**Your Ref: 2025/0740
Our Ref: A/03067**

38 Hoyle Mill Road, Stairfoot, Barnsley - (BARN) Erection of detached summer house in rear garden

1.) The drainage details submitted on drawing 'OUTBUILDING DRAWINGS' ID-01 dated 22/09/25 that has been prepared by Uppal Design is not acceptable. The following point(s) should be addressed:

## Proposed Block Plan

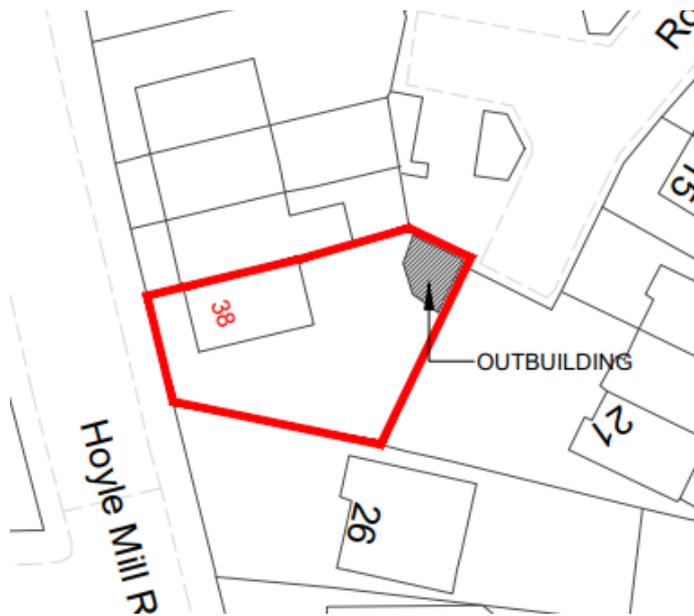
- a.) the submitted drawing appears to show a building proposed to be built-over the line of public sewer crossing the site -- contrary to our request
- b.) the submitted drawing should show the site-surveyed position of the public sewer crossing the site
- c.) the submitted drawing should show the required building stand-off from public sewer -- or an agreed alternative scheme

2.) On the Statutory Sewer Map, there is a 525 mm diameter public surface water sewer recorded to cross the site. It is essential that the presence of this infrastructure is taken into account in the design of the scheme.

- a.) It may not be acceptable to raise or lower ground levels over the sewer and we will not accept any inspection chambers on the sewer to be built over.
- b.) In this instance, a stand-off distance of 3.5 (three point five) metres is required at each side of the sewer centre-line and it may not be acceptable to raise or lower ground levels over the sewer, nor to restrict access to the manholes on the sewer.
- c.) A proposal by the developer to alter/divert a public sewer will be subject to Yorkshire Water's requirements and formal procedure in accordance with Section 185 Water Industry Act 1991.

3.) Given that the building has already been constructed, the developer is requested to provide foundation details in order that the effect on the public sewer network can be judged.
